From: Graham Beck [REDACTED]
Sent: 29 September 2015 16:17
To: Matthew Woodward
Cc: Neil Crowther
Subject: Oldlands Phase II -

"I am the case officer dealing with the application above. I have looked through the contents of the application and at this stage, I require clarification and further information in order to address the following points of concern:

Figure 2b: Oldlands Farm Phase 2 Illustrative Masterplan B2 Use (Davis Landscape Architects, 2015)

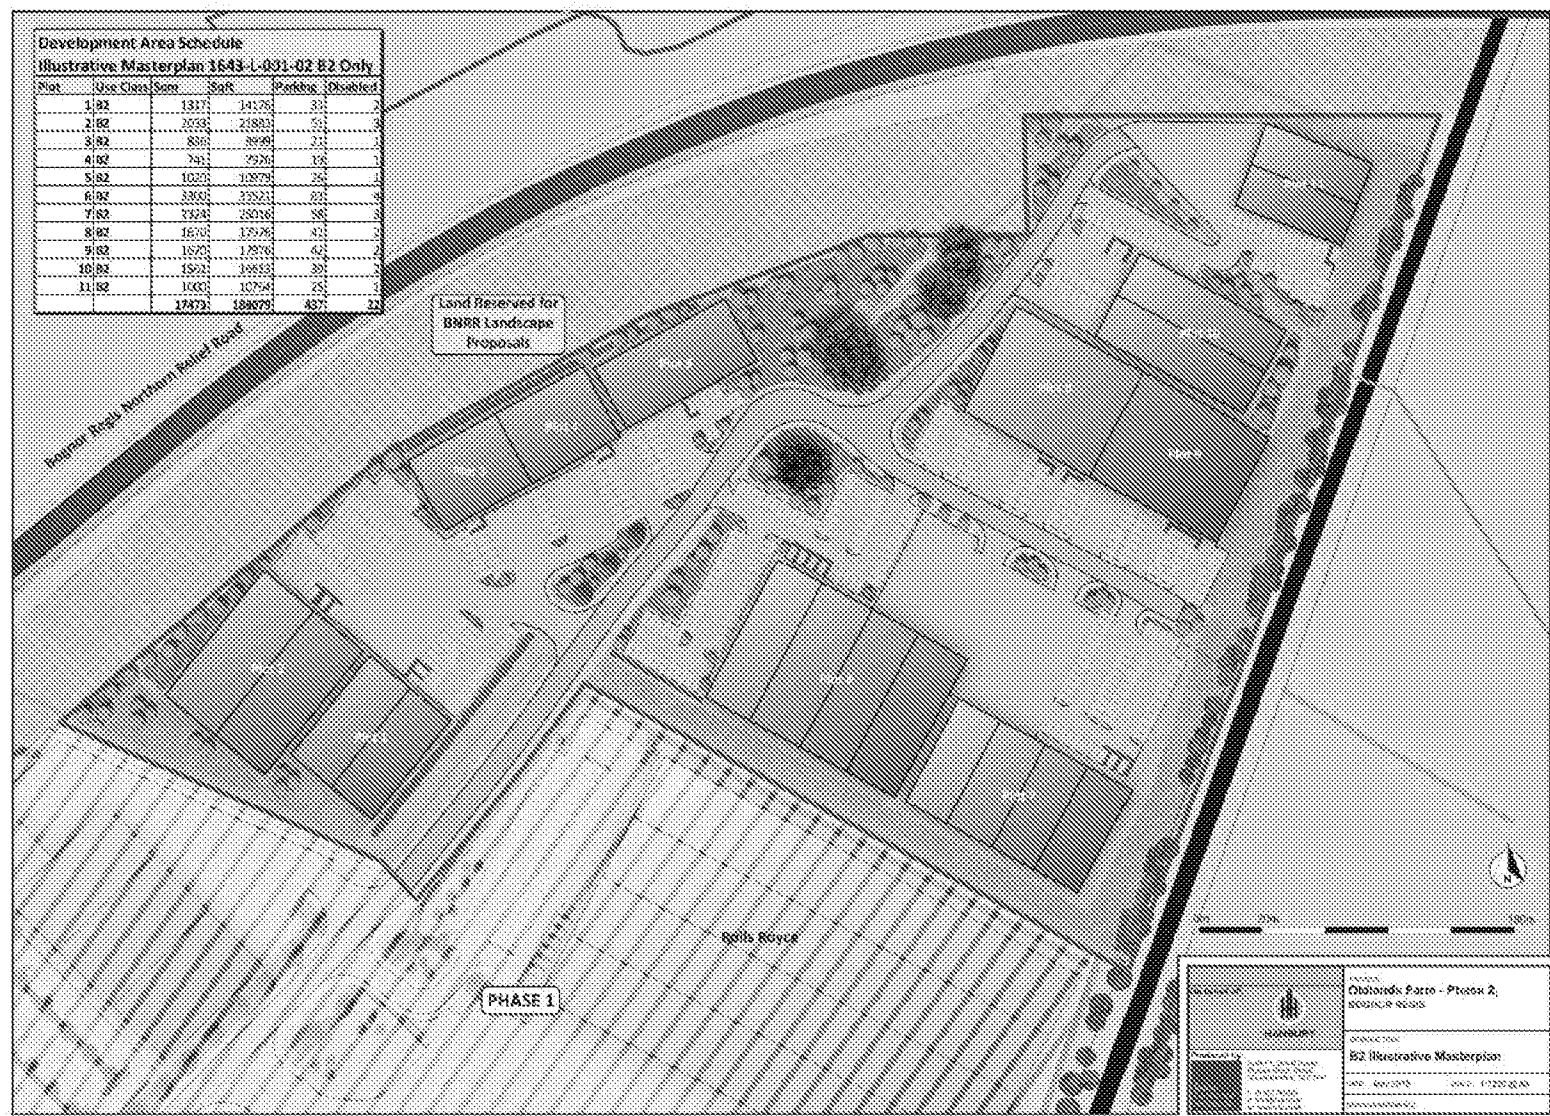
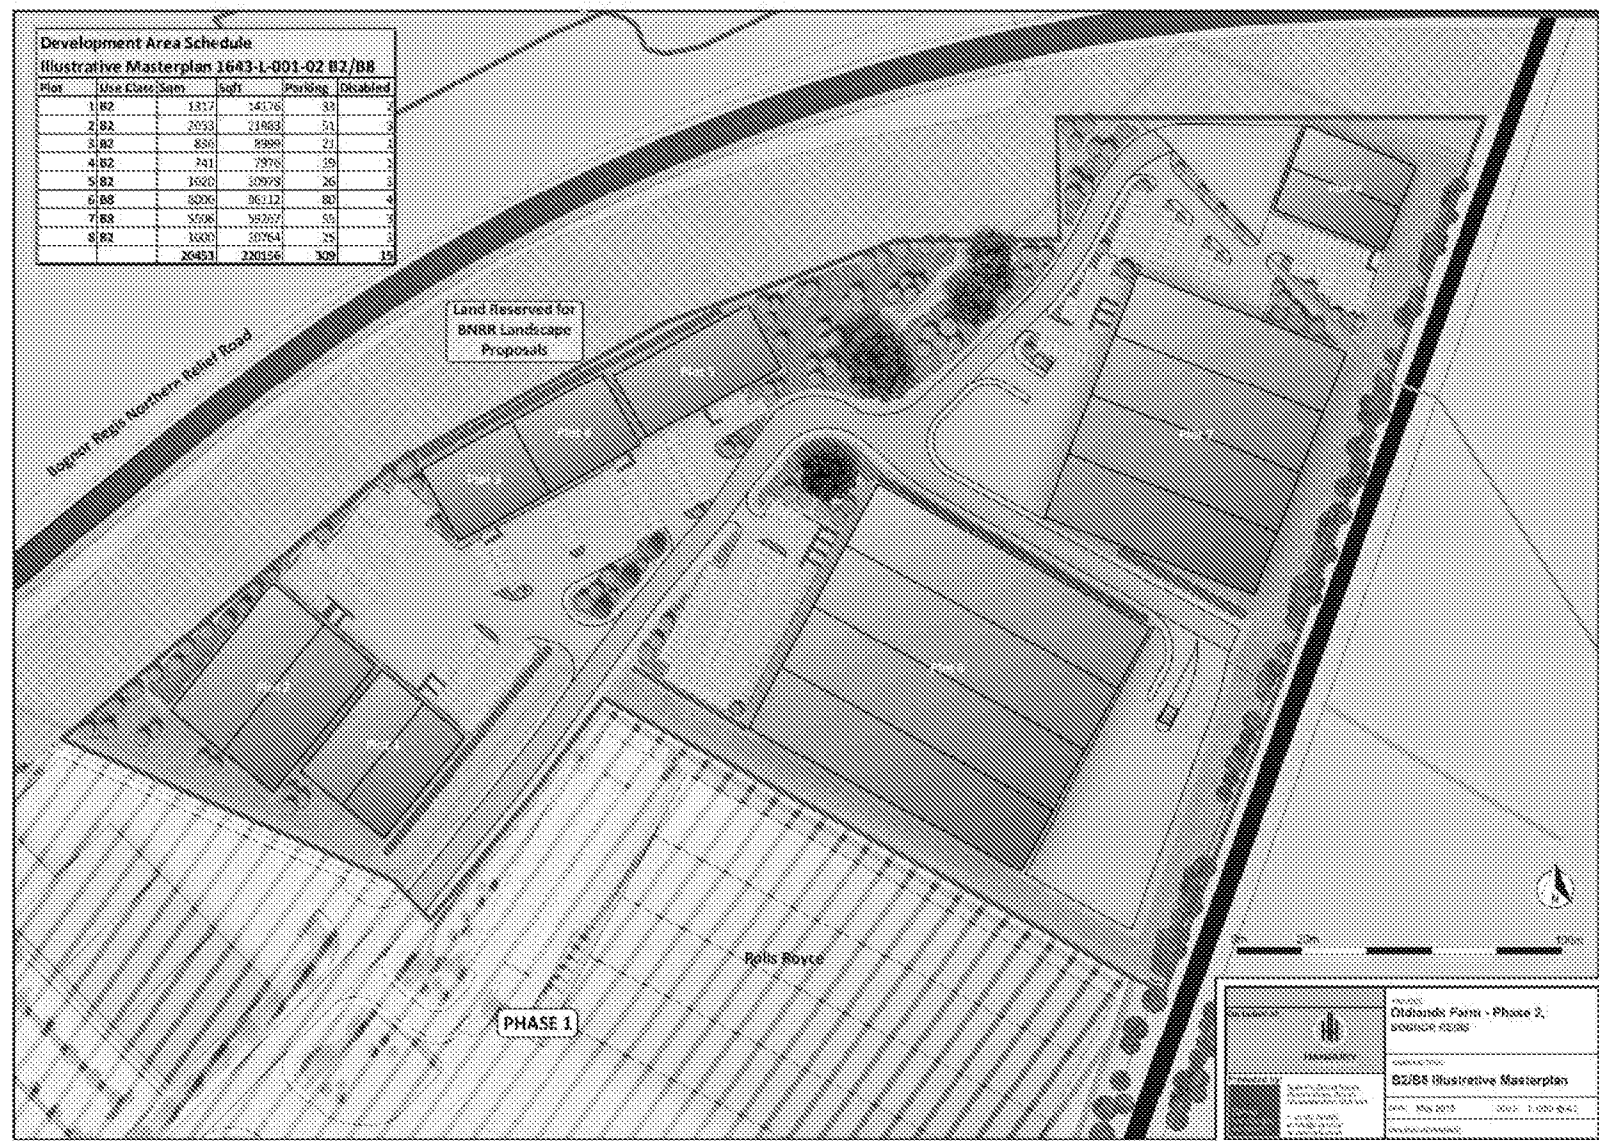
> - Can you please check the masterplan to ensure the BRNRR relief road is in the correct position and the access point is correct? I can confirm the plan is correct.

TYPICAL SECTION THROUGH
FLOOD CHANNEL

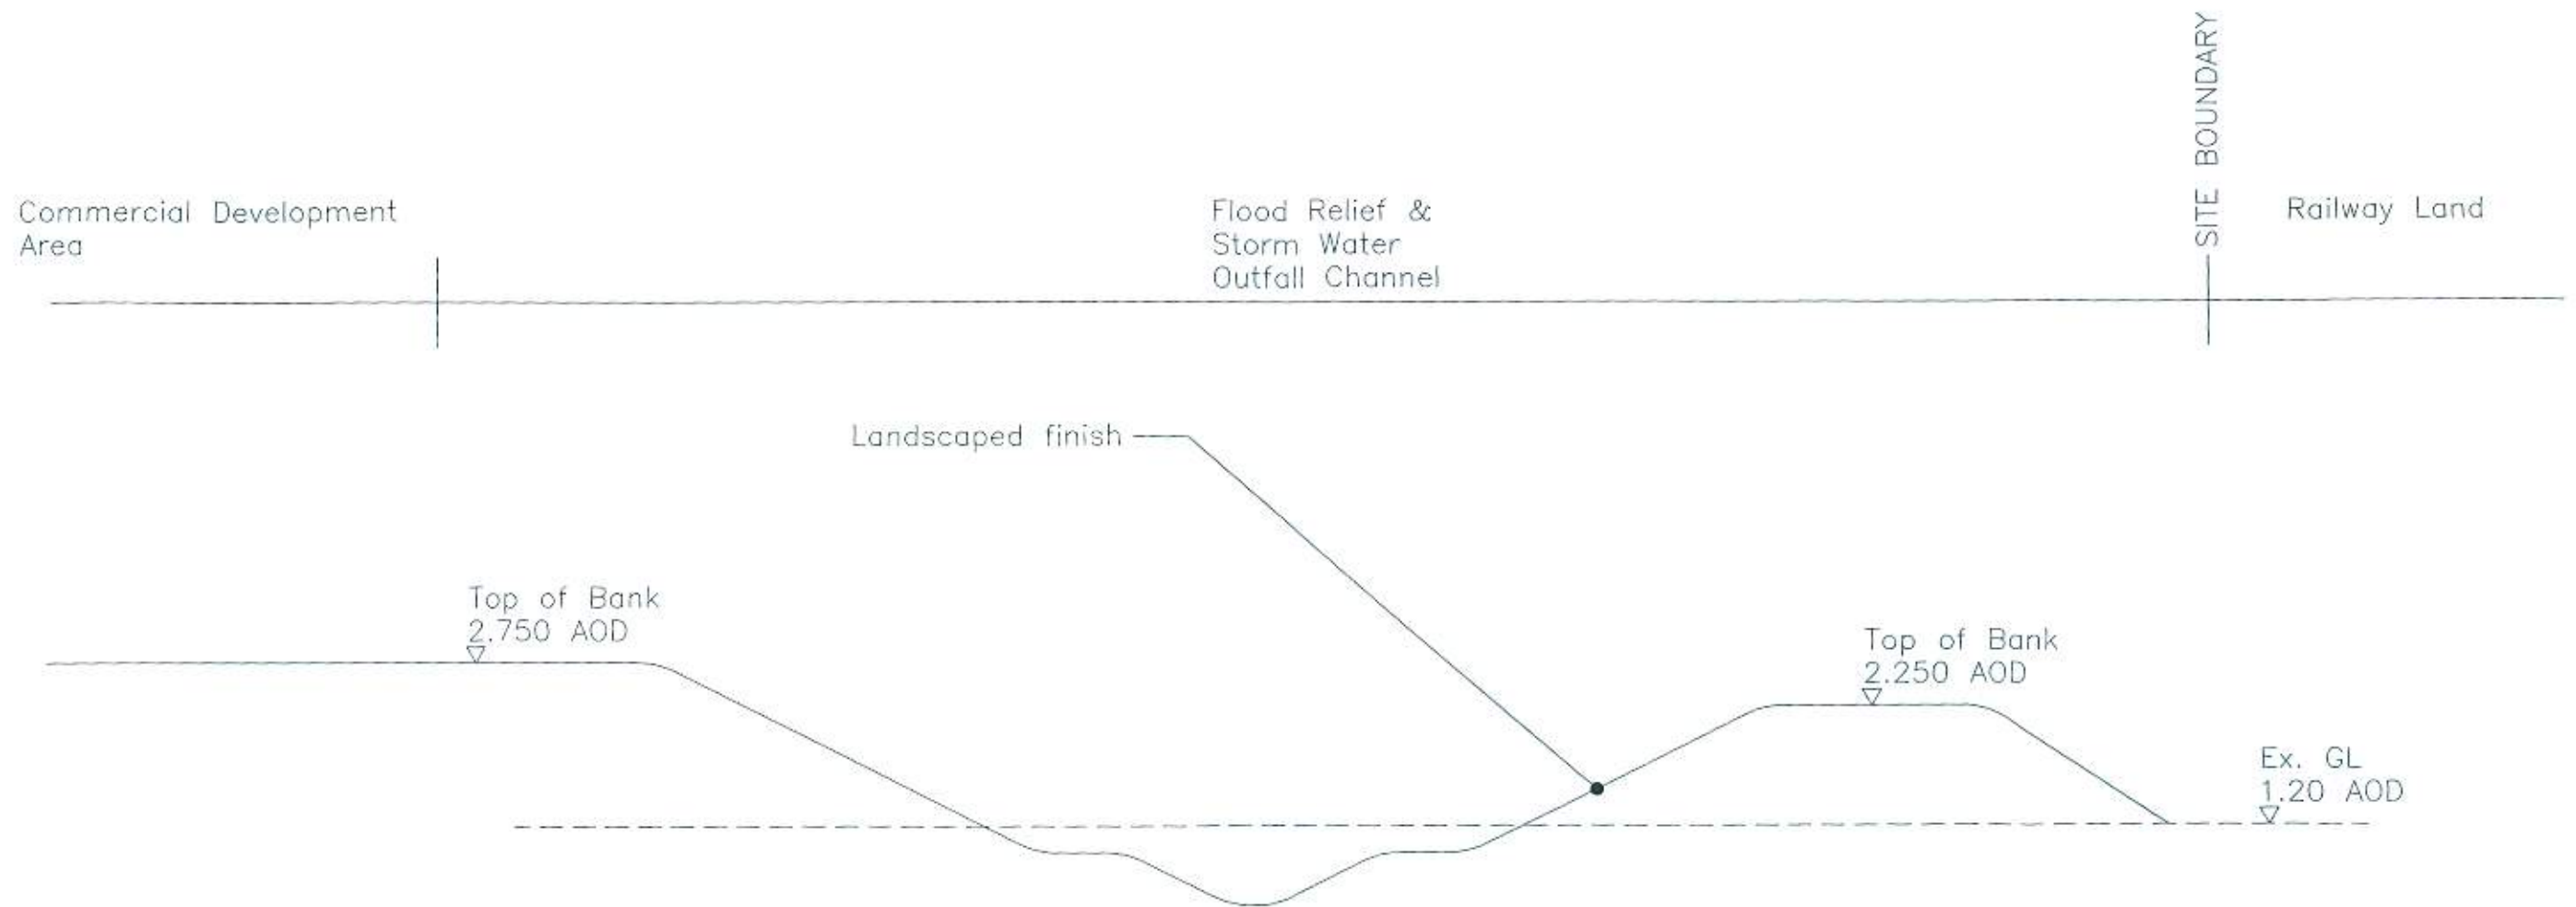
> - Flood compensation area. More detail required. I understand that the flood compensation area to the north proposes to extend the existing flood compensation area and, essentially, the movement of materials to attenuate flood risk will comprise 'cut and fill'. The topographical plans are not easy to interpret and I require a more illustrative plan. I would recommend the submission of a 'grid' plan or other similar illustrative tool to demonstrate the change in levels across the northern and southern portions of the site. I have discussed this matter with the engineer and he has drawn my attention to the drawings referenced 5130-01 Raised Levels Plan; 5130-02 Prelim Compensation Area and 5130-03 Raised Levels Sections all of which are to be found with the FRA / Drainage Strategy. These types of drawings were submitted to support the Oldlands Phase One application which drawings were deemed acceptable and were approved.
